Your Ref: OWPC20347
Our Ref: AW/237/18/HH 20-08-2018
Please ask for:
Amber Willard

Front single storey extension & roof alterations.
28 Apple Grove Aldwick

Thank you for your internet representation made on 30th October 2018 which has been recorded as '**an objection**' with the comments as follows:

sheet 2 of 3

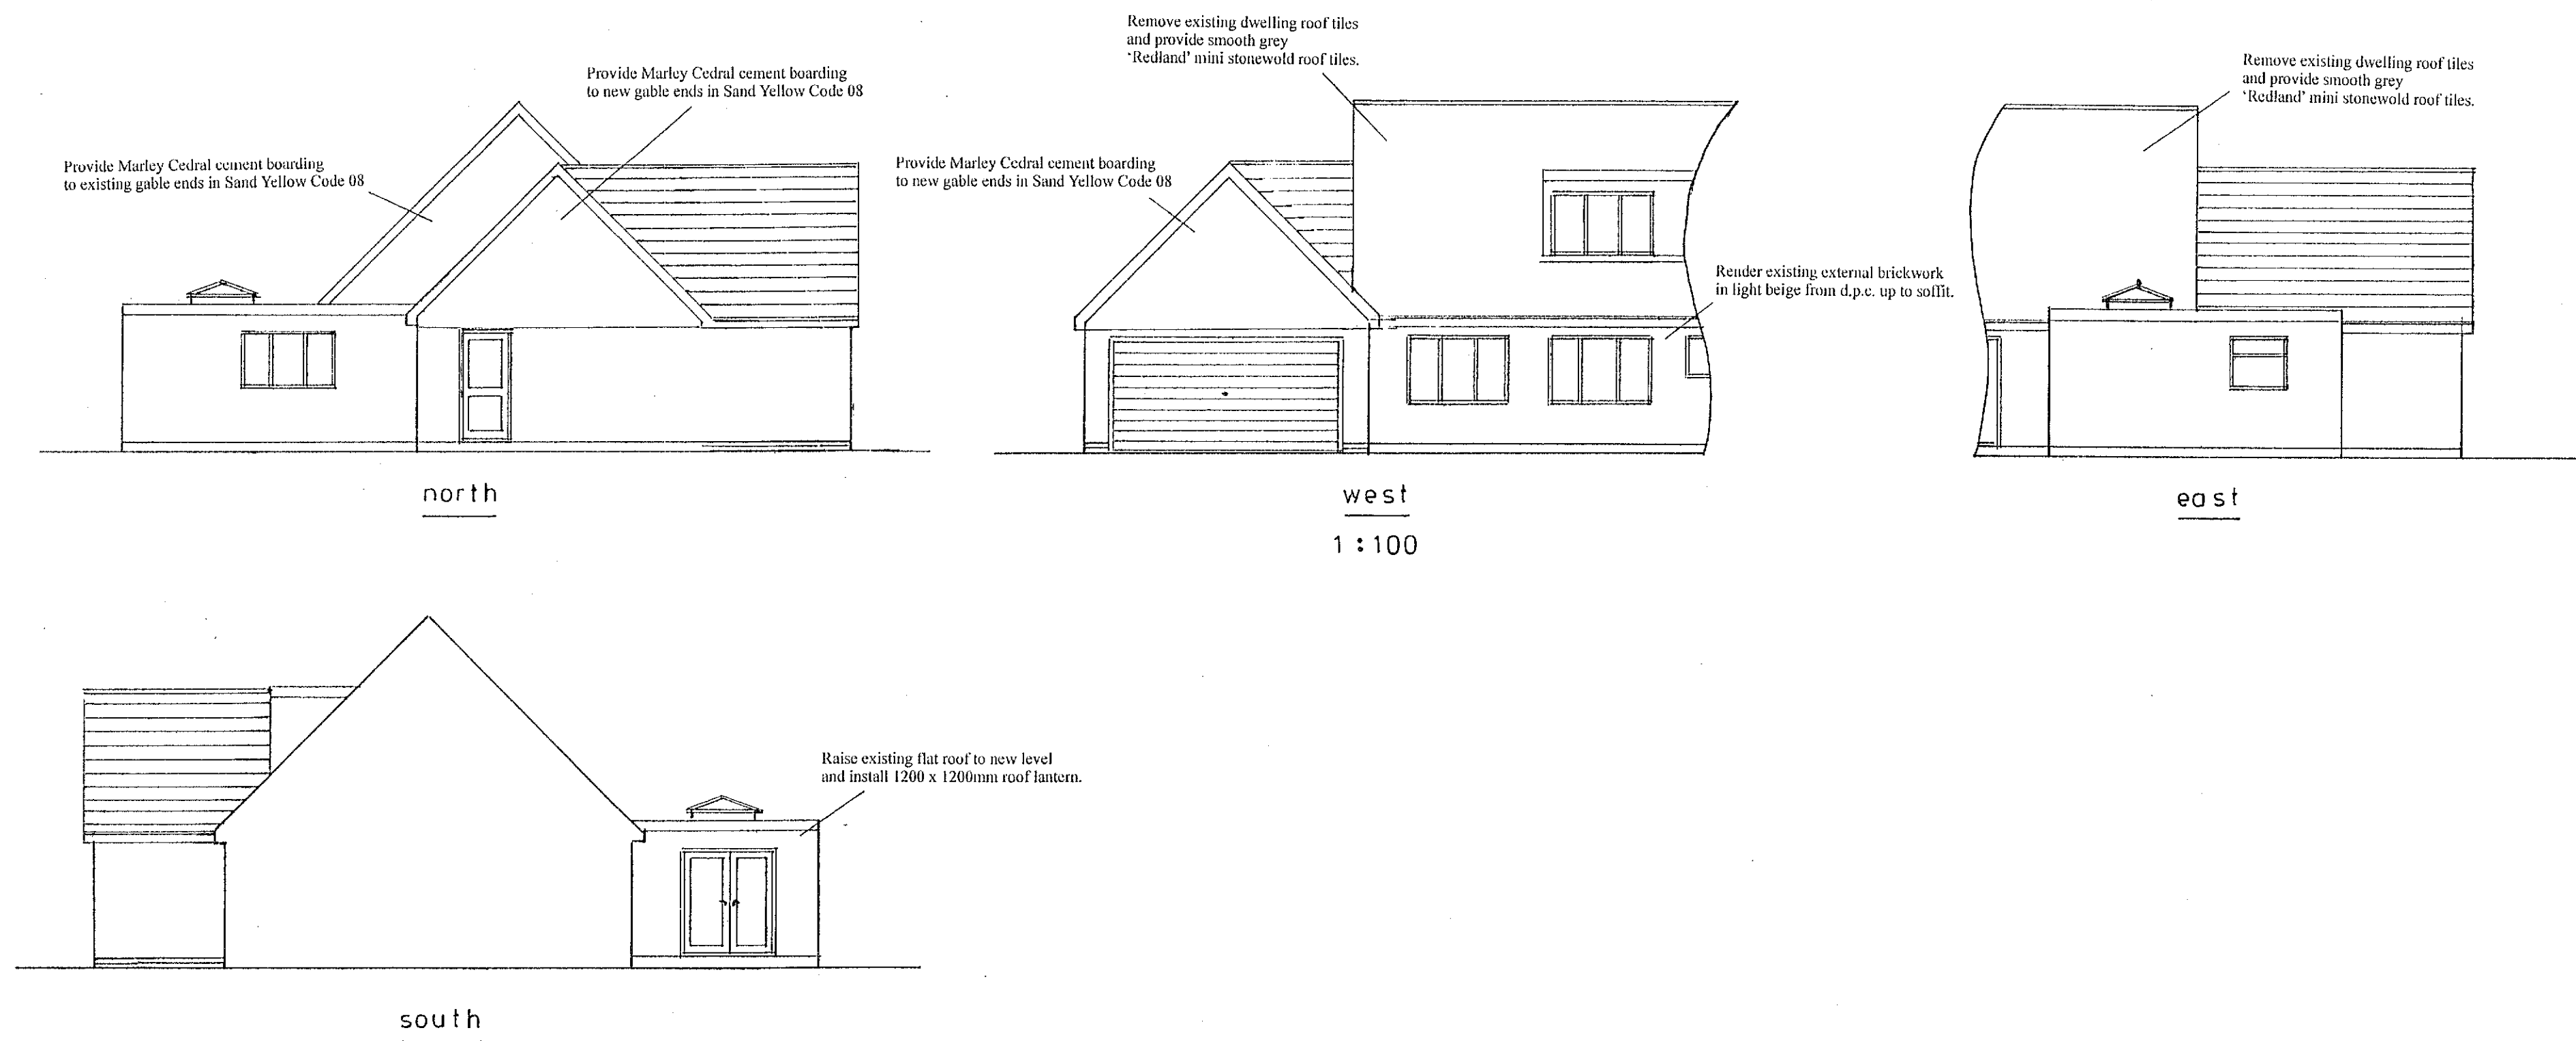
We live at 27 Apple Grove, immediately to the north of the proposed development and are most concerned that, if this development is permitted, it would overshadow our southern elevation which only has windows on the ground floor. In particular the autumn and winter sun, which is then much lower in the sky, would not get above the new garage skyline resulting in a gloomy sitting room and kitchen whereas at present the light is able to come in through the kitchen and sitting room windows facing No. 28.

We have the right to natural light and do not want to lose this due to overdevelopment or overextension to our neighbour's property. Their present arrangement uses a flat roof. I am sure that a change to lower the roof line would allow the new facility that our neighbours are looking for without affecting our natural light.
